# ENG-MS21002-R1-FDR.pdf Markup Summary

<div>PRELIMINARY DRAINAGE</div> <div>BRADLEY POINT FIL</div> <div>EL PASO COUNTY, CO</div> <div>IN BLUE BOXES WITH BLUE TEXT</div> <div>December 2020</div> <div>Page 10 of 10</div>	<div>Subject: PCD Comment Legend</div> <div>Page Index: 1</div> <div>Date: 4/2/2021 2:19:13 PM</div> <div>Author: dsdrice</div> <div>Color: </div> <div>Layer:</div> <div>Space:</div> <div>Page Label: 1</div>	
<div>See comment memo also.</div>	<div>Subject: Text Box</div> <div>Page Index: 1</div> <div>Date: 4/2/2021 2:19:32 PM</div> <div>Author: dsdrice</div> <div>Color: </div> <div>Layer:</div> <div>Space:</div> <div>Page Label: 1</div>	See comment memo also.

ROADSIDE DITCH CONVEYANCE EXHIBIT

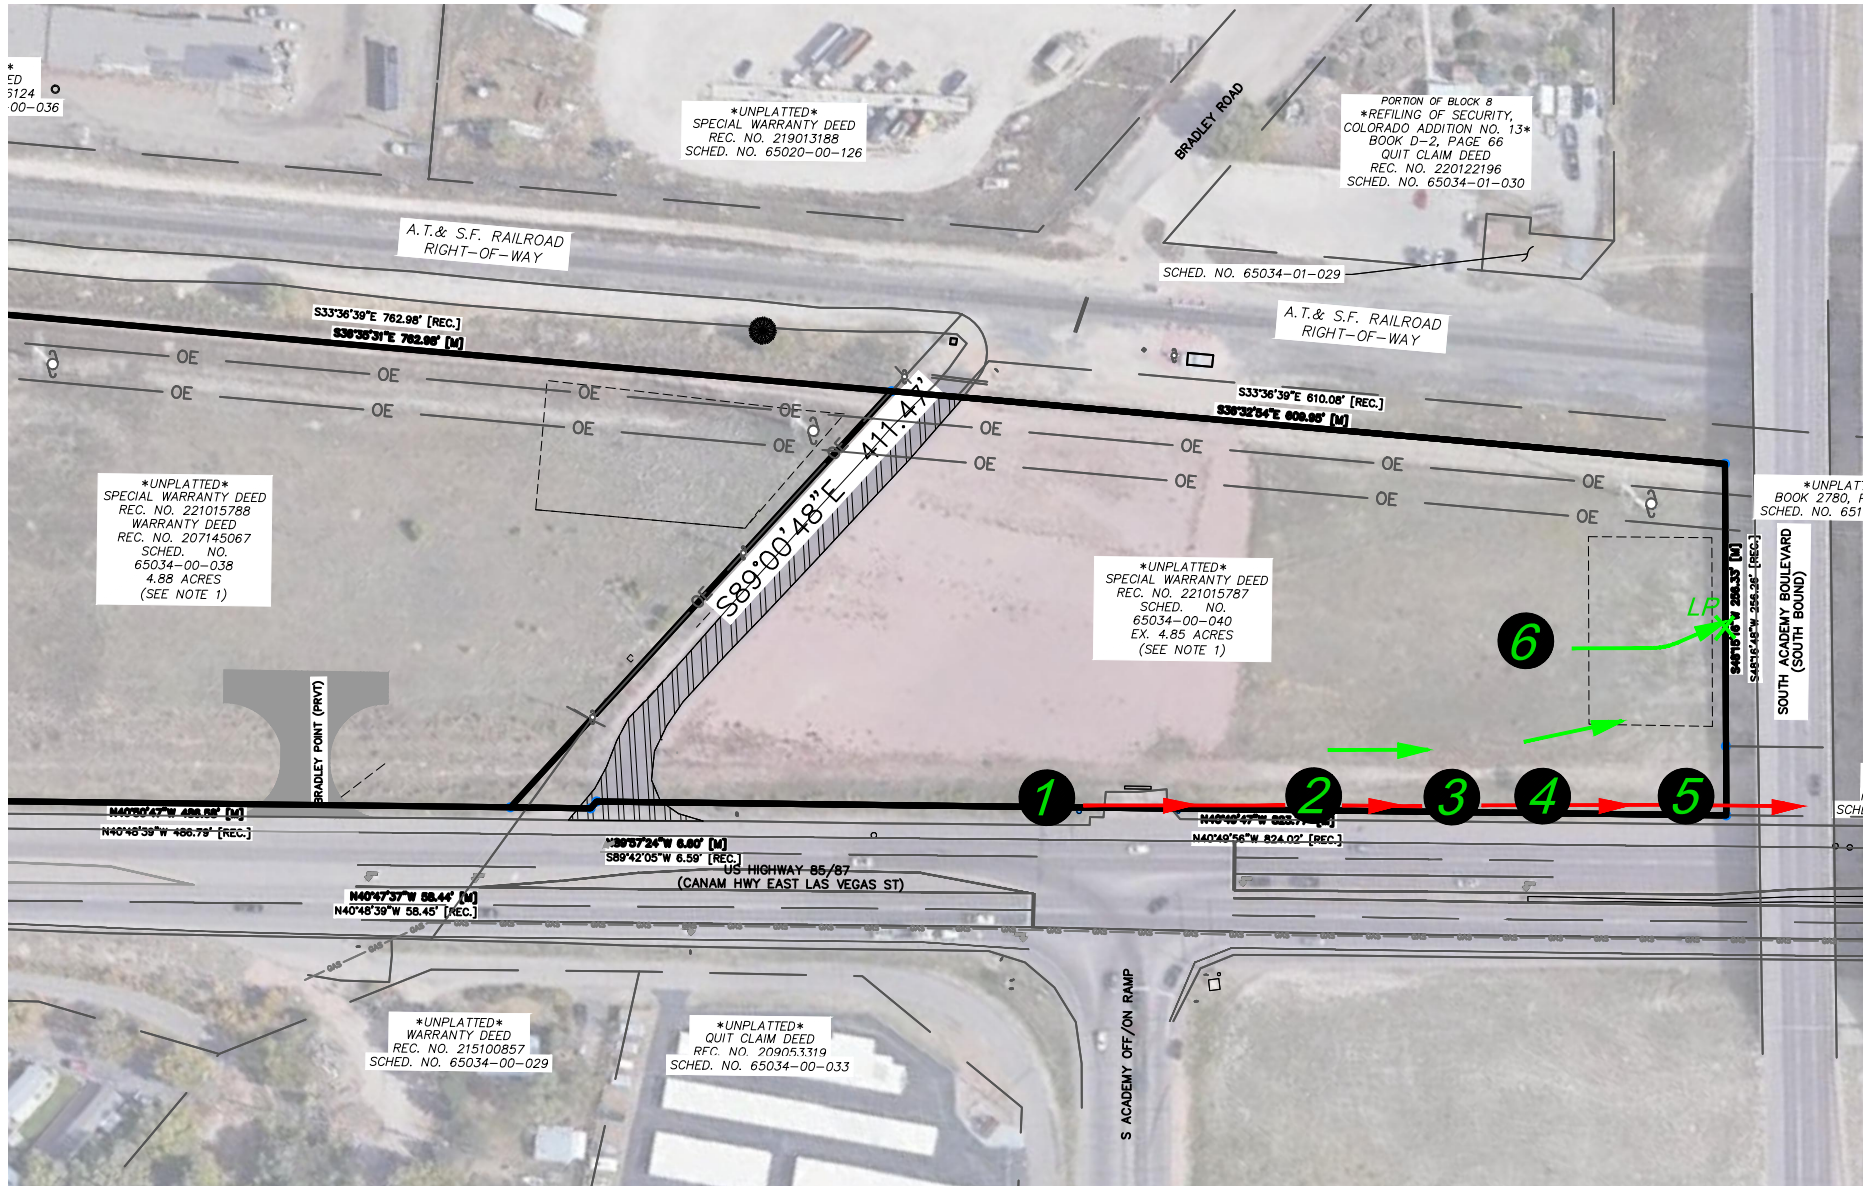
Provide roadside ditch and downstream conveyance calculations.

BRADLEY POINT FILING NO. 1
EXISTING DRAINAGE MAP
DATE SUBMITTED: 08/21/23
SHEET 1 OF 1

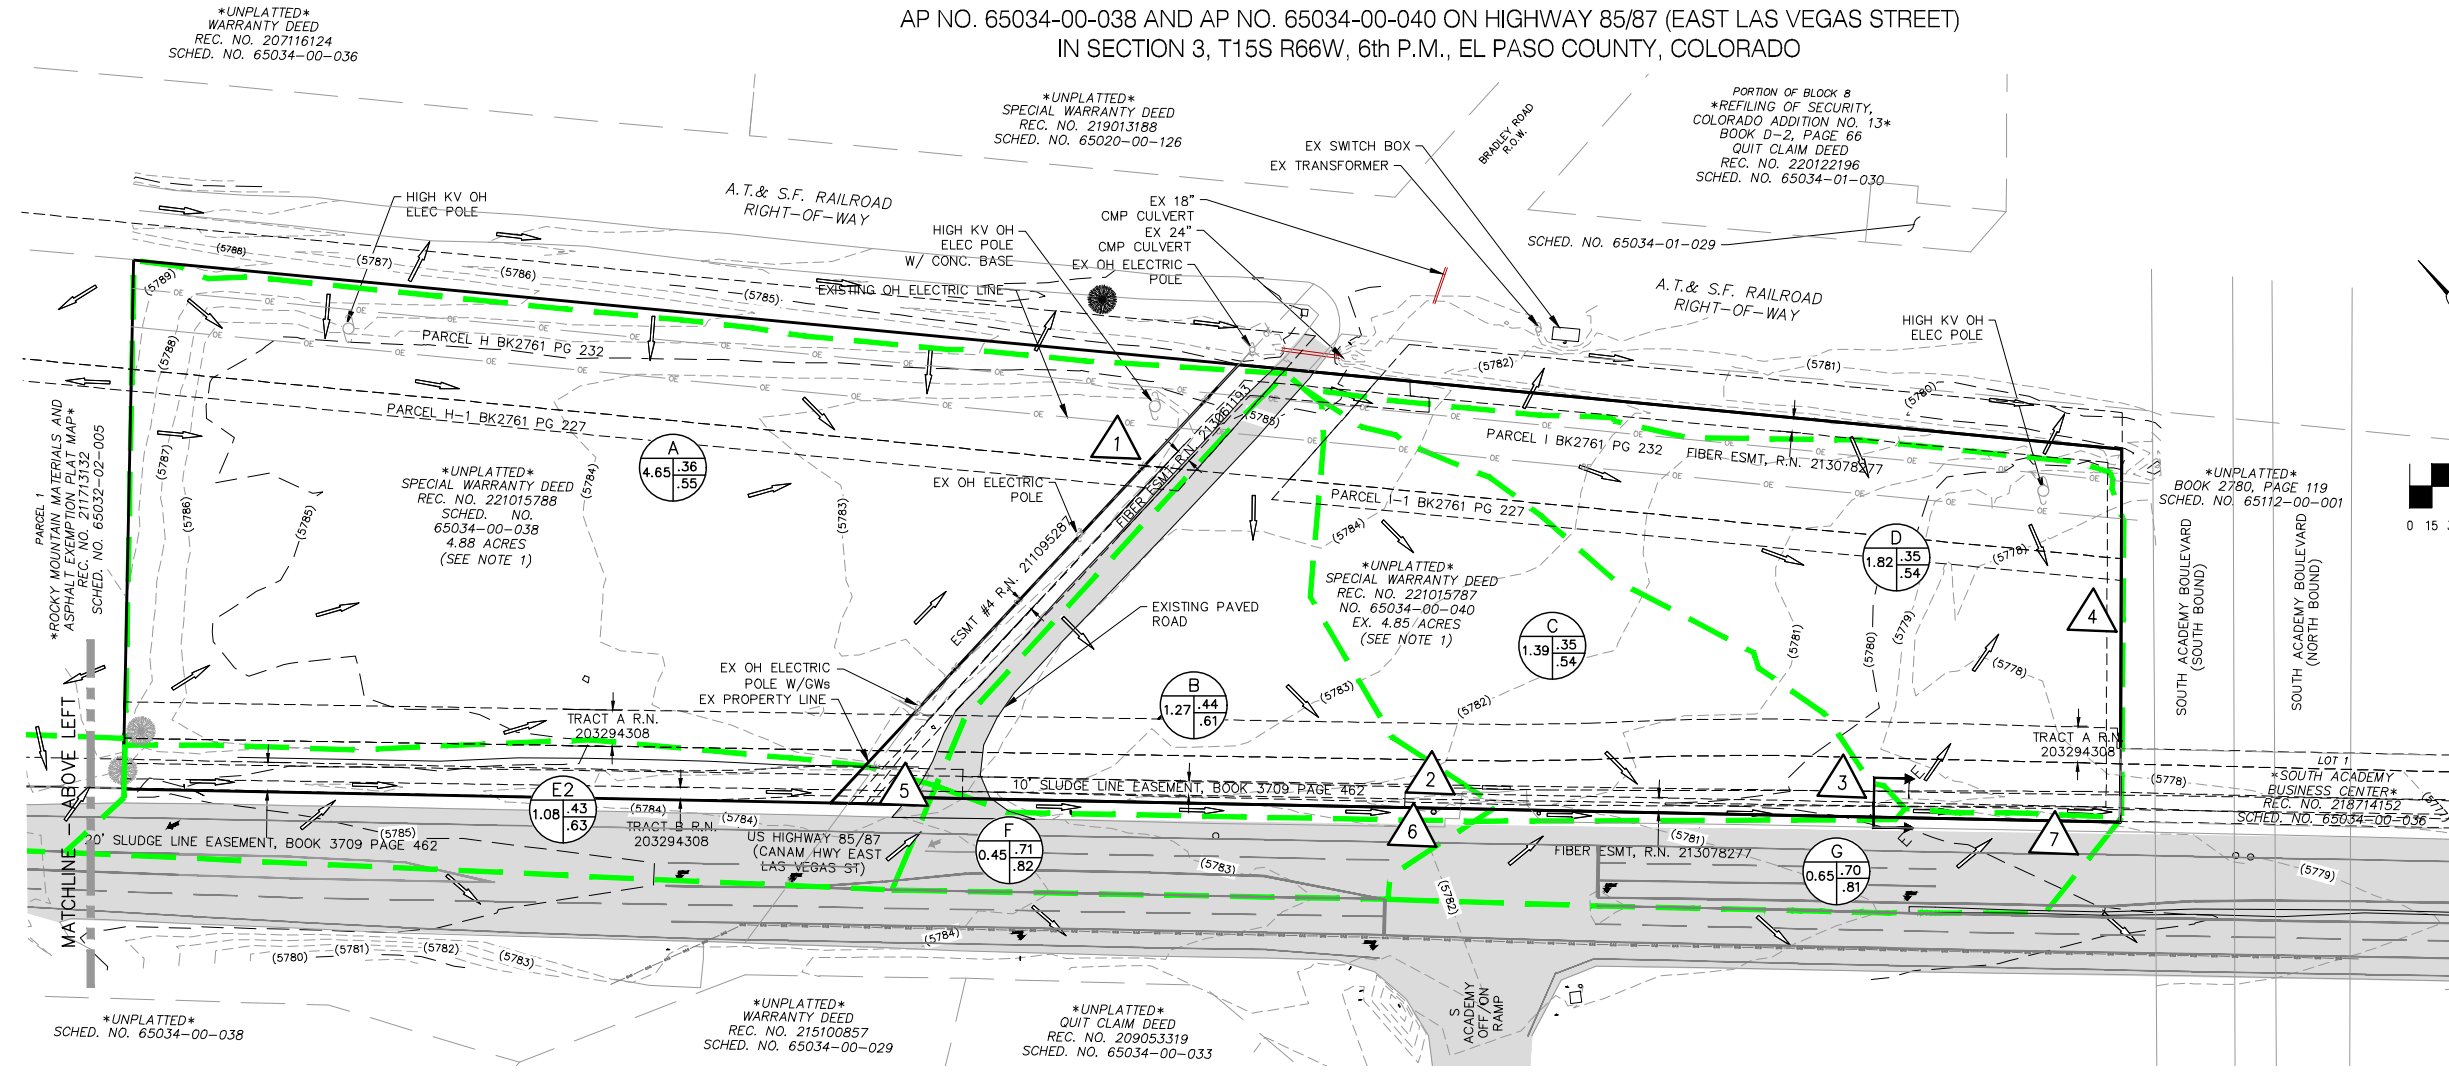
This is a wide swale - developed release needs to approximate this condition unless a drainage easement has been obtained for the proposed point discharge.

Does the ditch have capacity or do flows enter the site?

BRADLEY POINT FILING NO. 1
PROPOSED DRAINAGE MAP
DATE SUBMITTED: 04/20/23 SHEET 1 OF 1

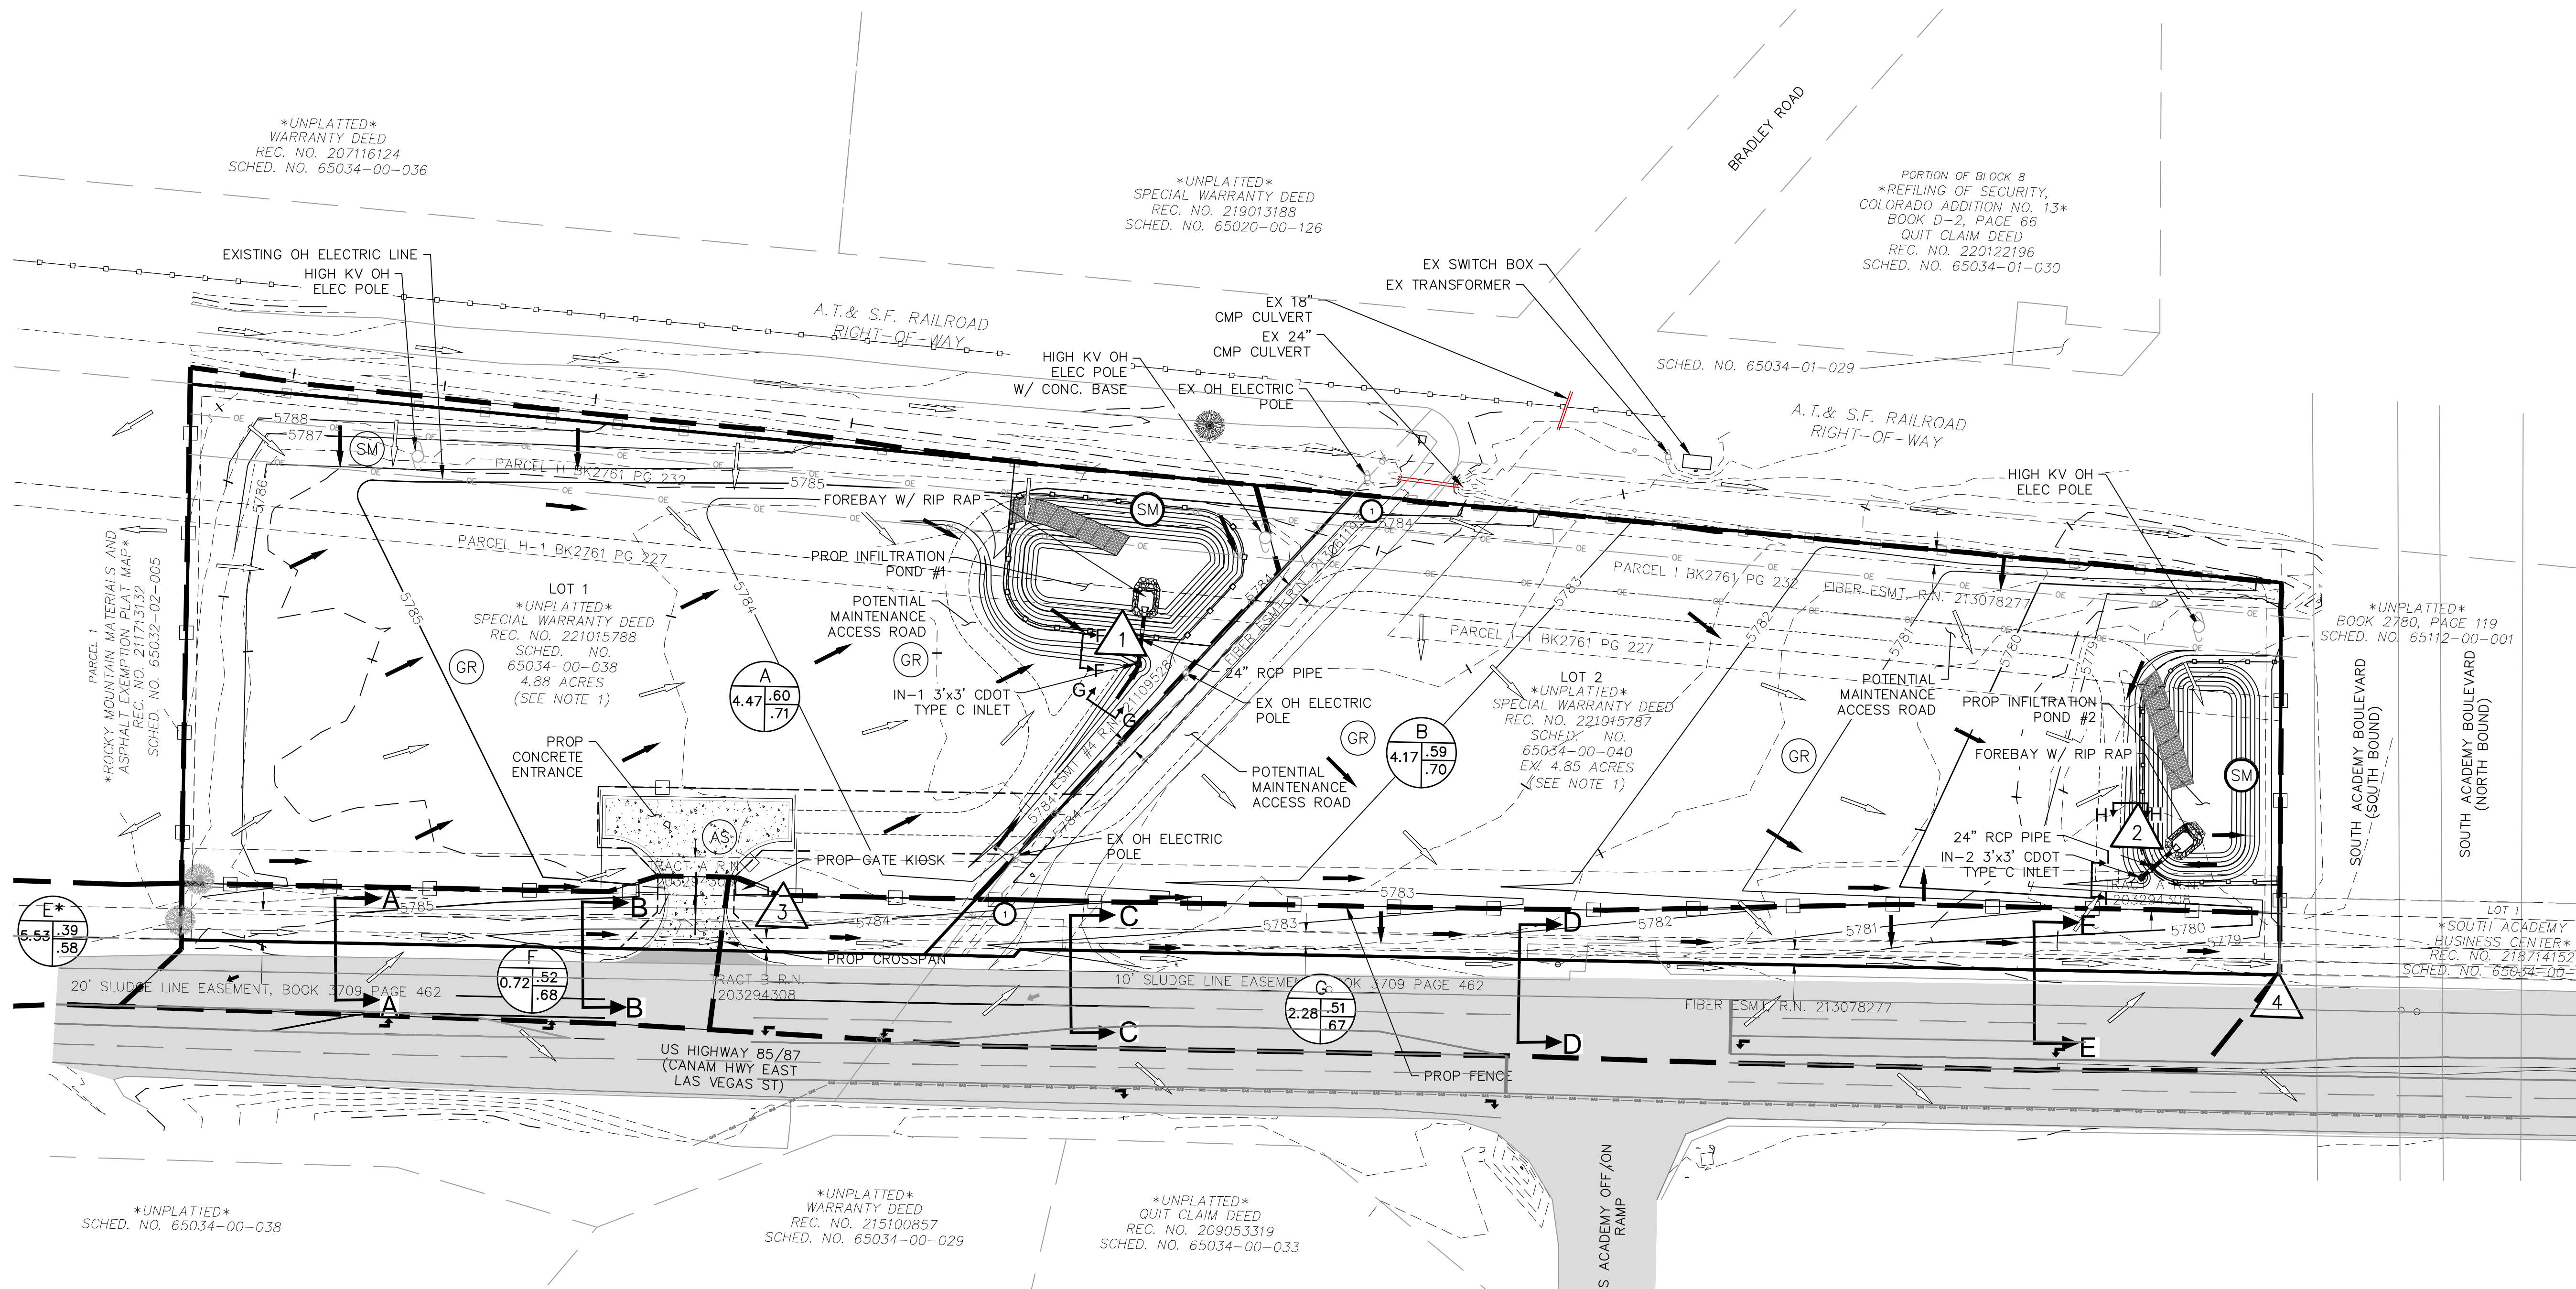
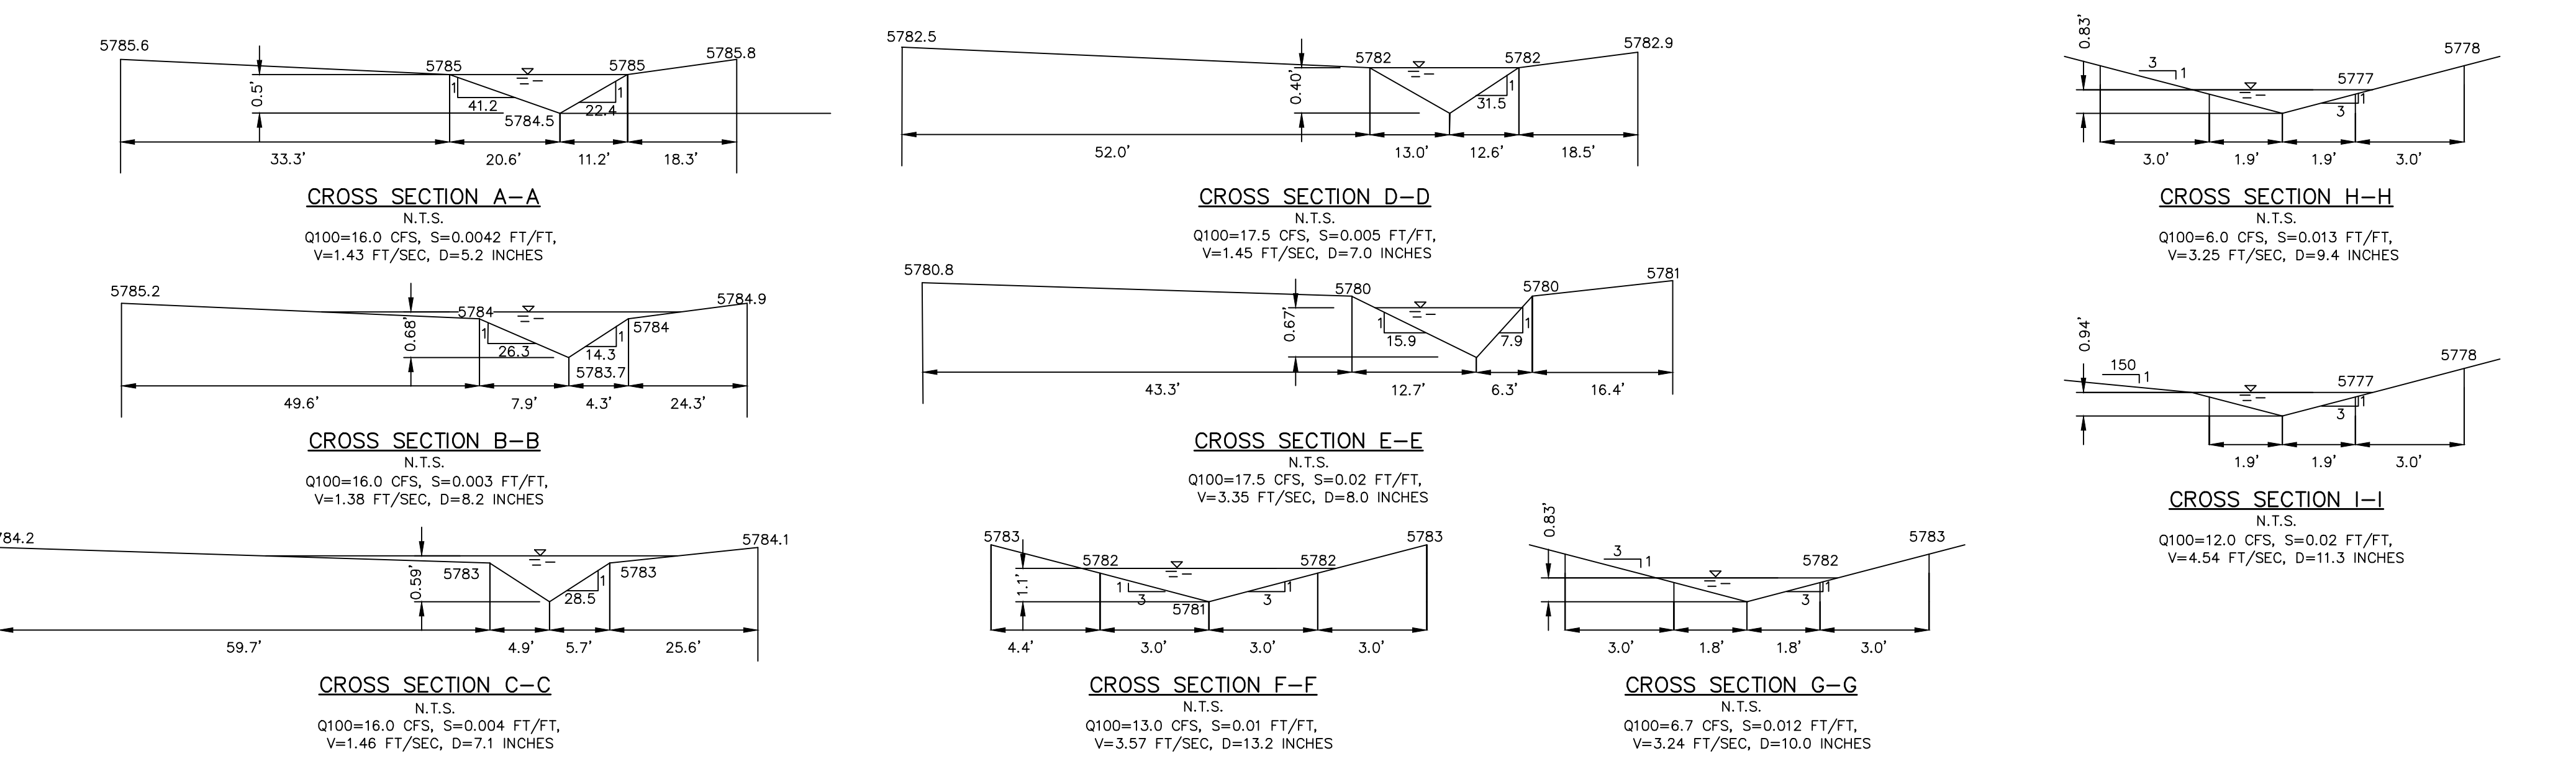
Show the downstream conveyance if there will be a point discharge

The overflow spillway should be located in the historic swale location

provide a forebay with inflows directed to it

Is fill being placed into the ditch? How will flow be conveyed? CDOT needs to approve any revisions.

Provide roadside ditch cross-sections at DP 5 and DP6 and capacity calculations

Do ditch flows transition to sheet flows?

How will the storage area be separated from the ponding area?

Add the orange line to the legend
